COMMUNITY SERVICES DEPARTMENT

May 3, 2021

Subject: 13580 Bridle Bit Road Re-Plat (VR-216)

Terra Benedetta Subdivision

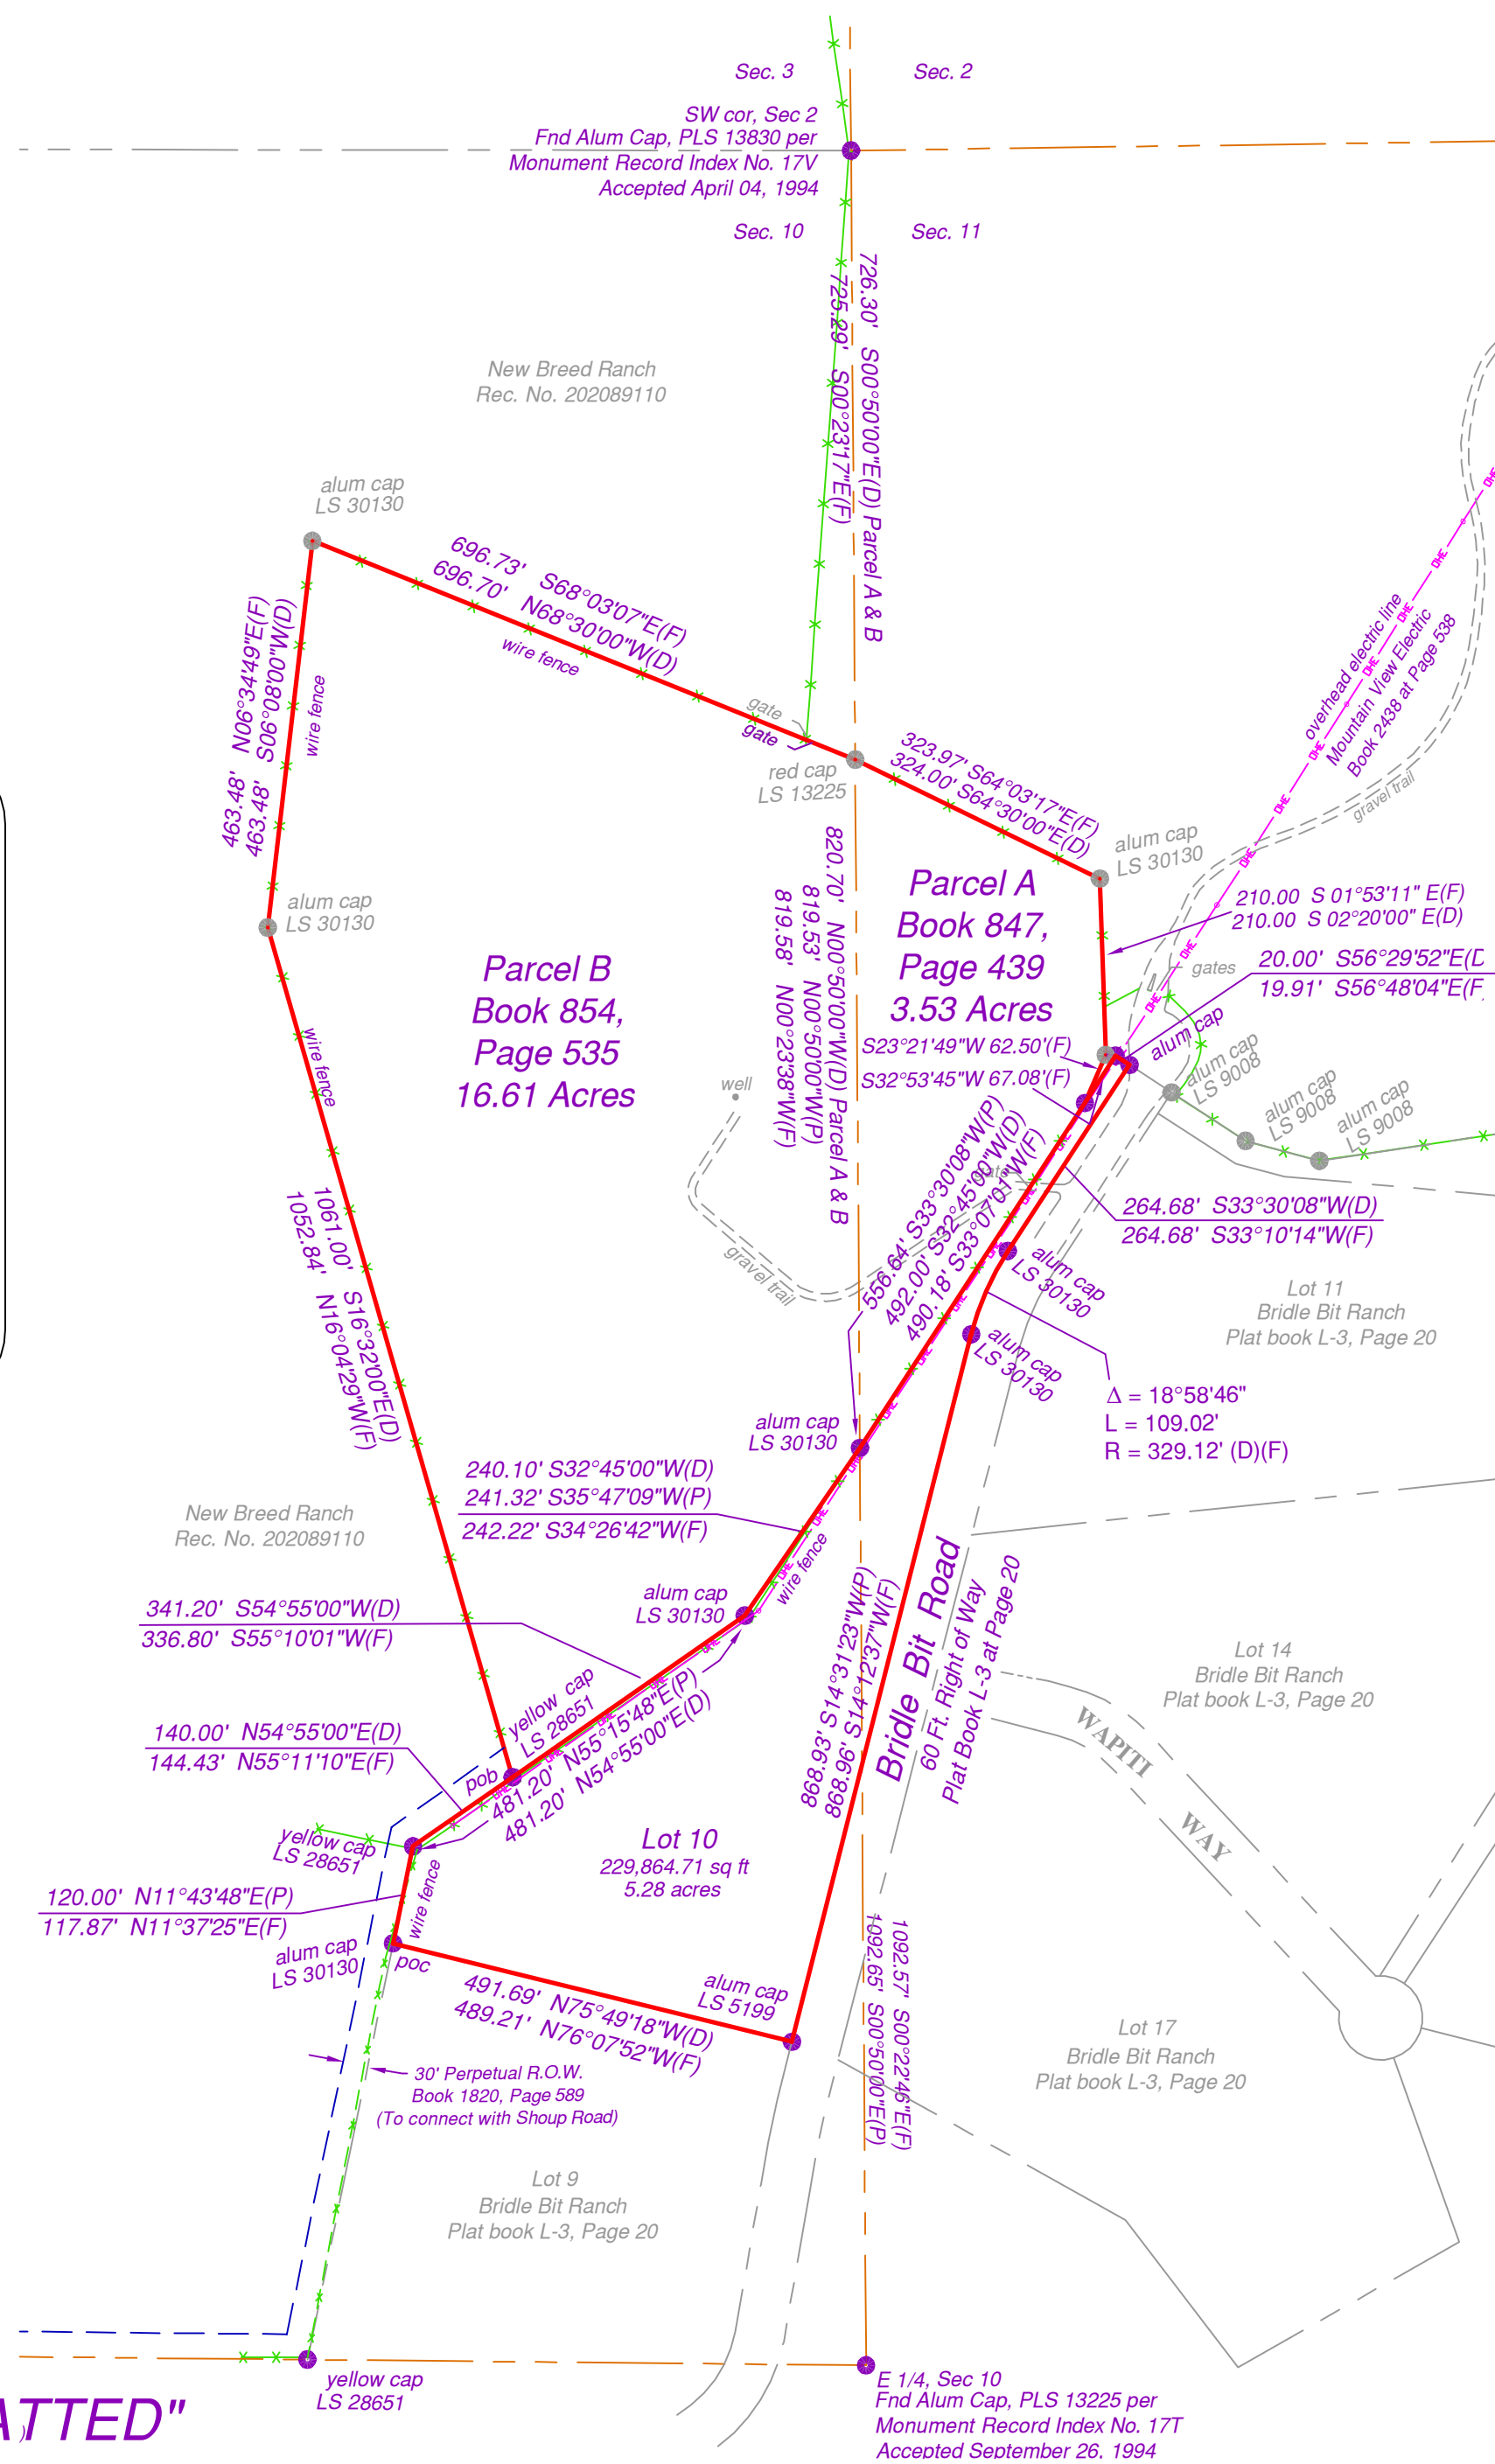
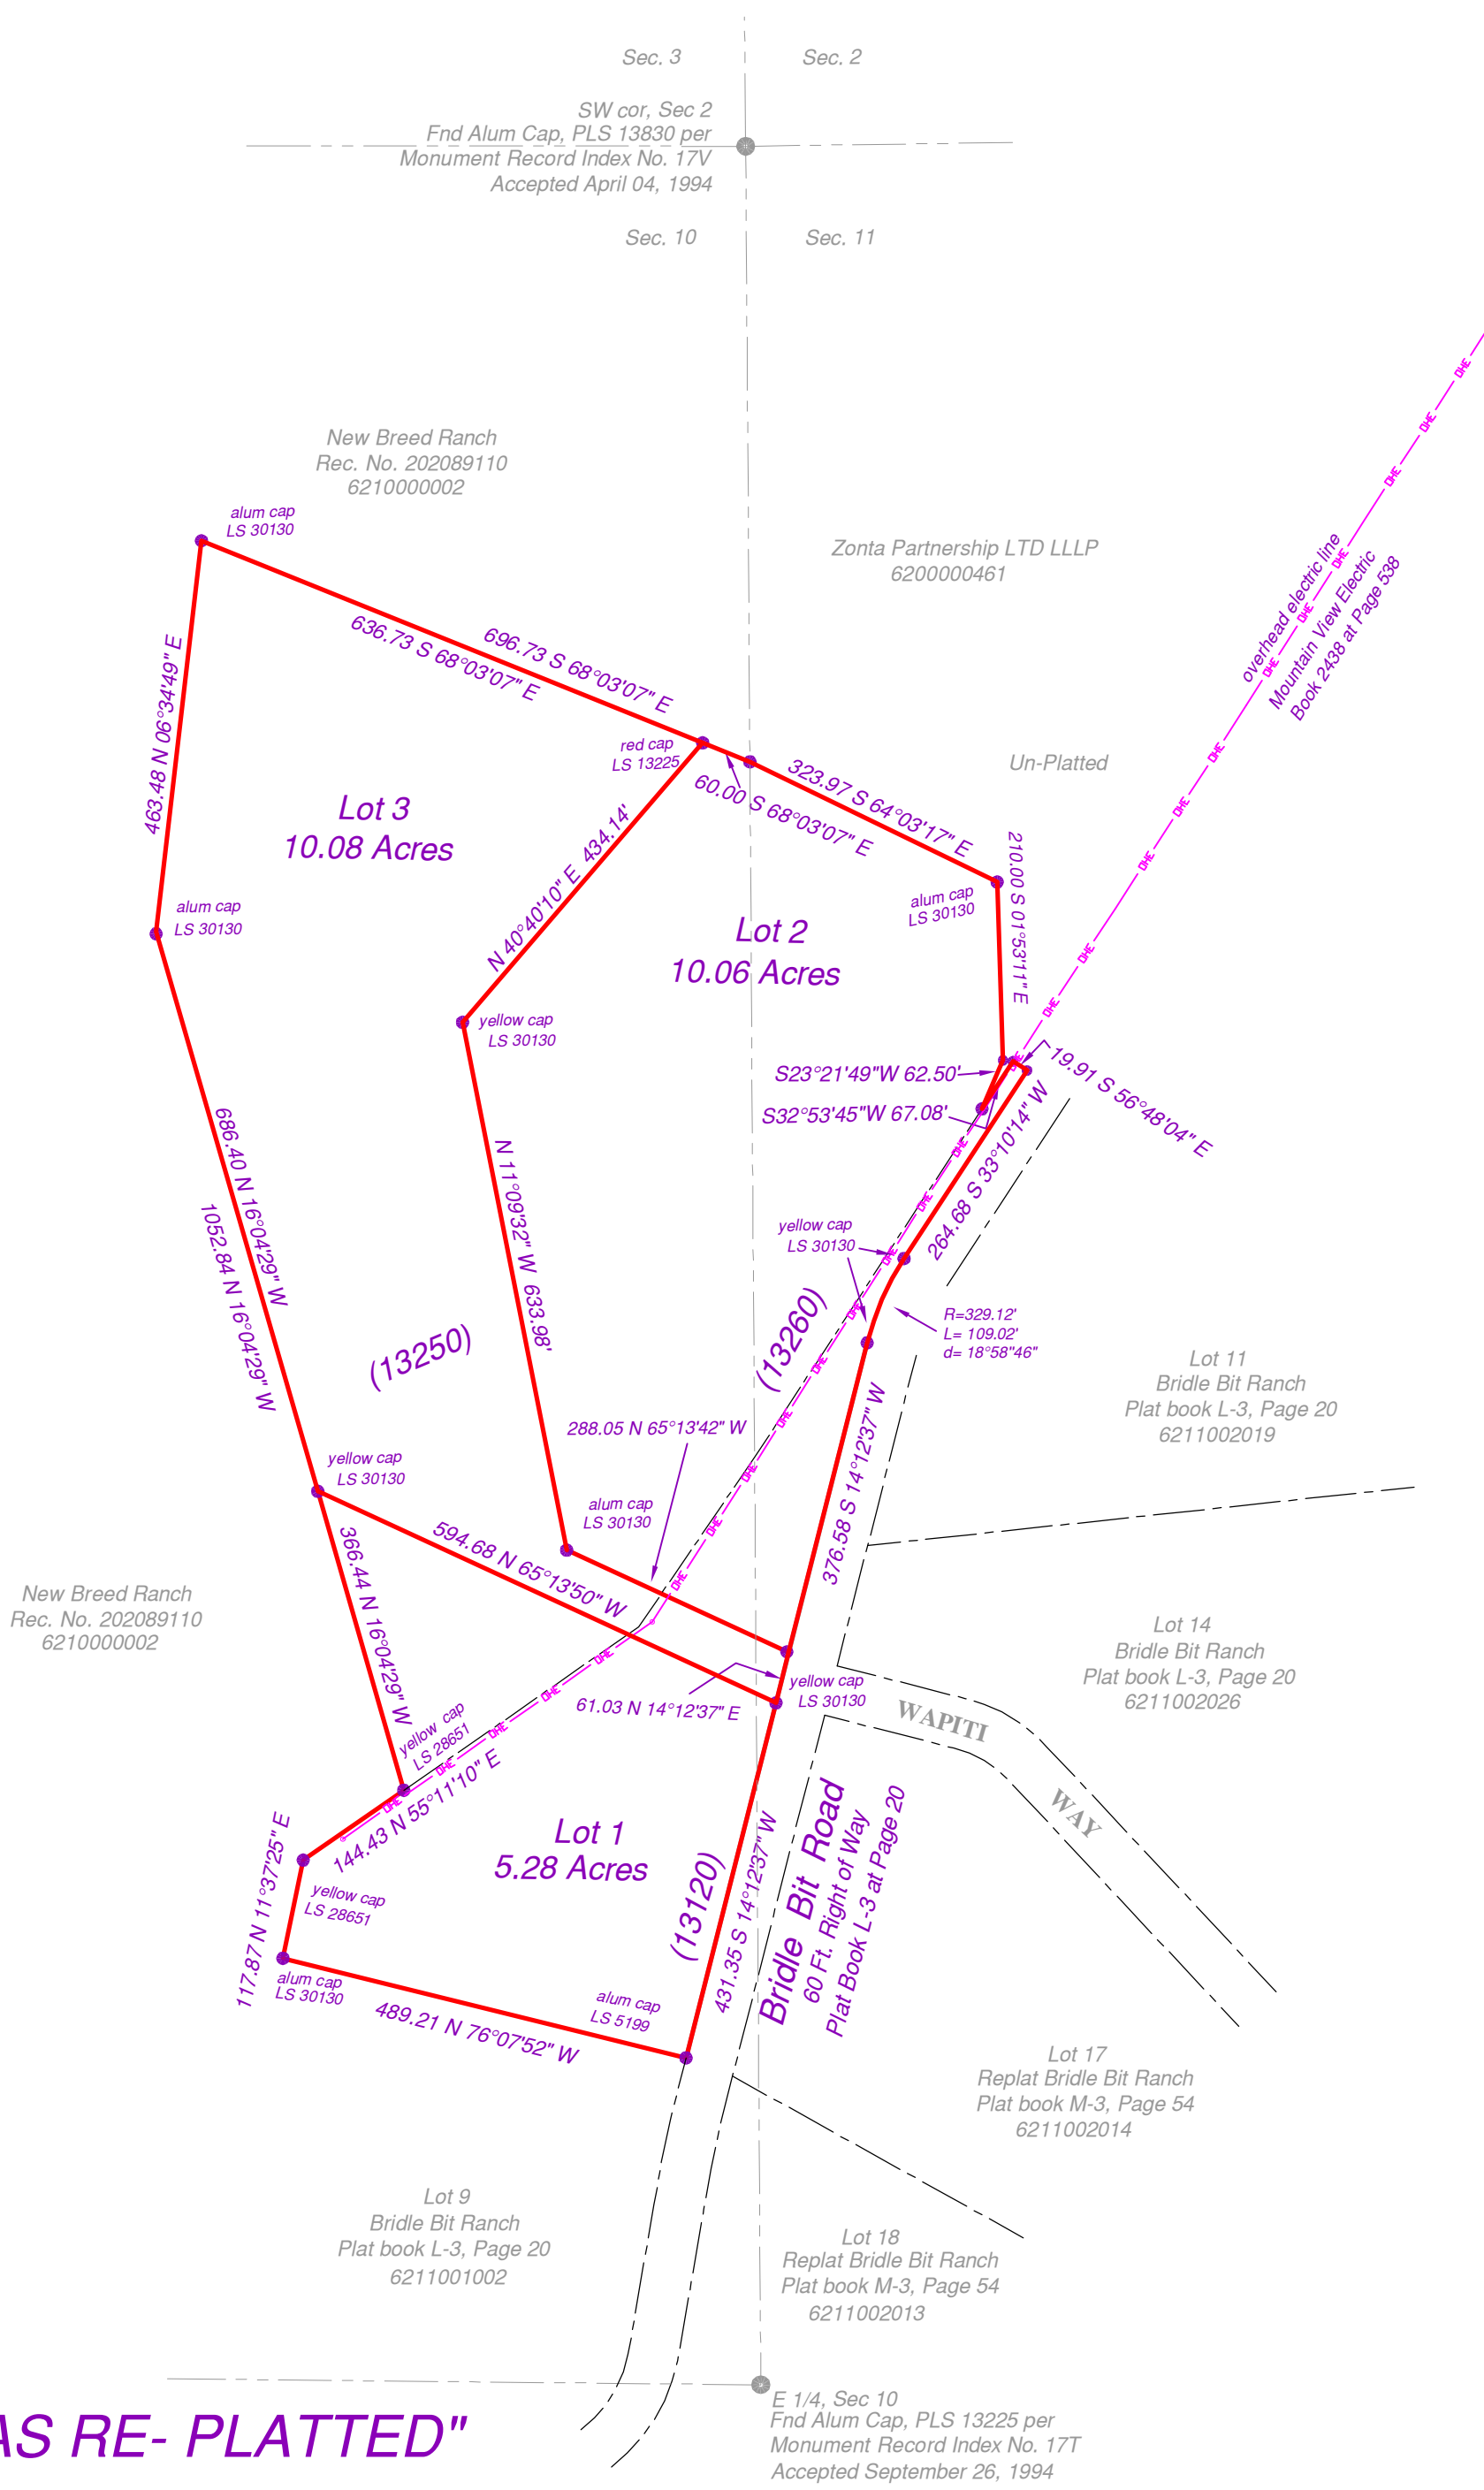
County Parks requests trail easements where development projects impact proposed County trails. As it pertains to this application, the County requests that the landowner provide a 25-foot public trail easement along the west and north side of the subdivision. Since this easement is not shown the re-plat drawings, Staff asks the easement be shown on the Final Plat Drawing. Required El Paso County Park fees will be required for two residential lots because fees were previously paid for Lot 10 as part of the original Bridle Bid Subdivision.

The Park Advisory Board recommends that the Planning Commission and the Board of County Commissioners include the following conditions when considering and/or approving the Oak Ridge Estates Filing No. 2 Final Plat: (1) Require fees in lieu of land dedication for regional park purposes in the amount of \$920 (2) Provide to El Paso County a 25-foot trail easement along the west and north side of the subdivision that allows for the construction, maintenance, and public access of the LaForet Regional Trail, and dedicate the aforementioned easement to El Paso County with the recording of the Final Plat.
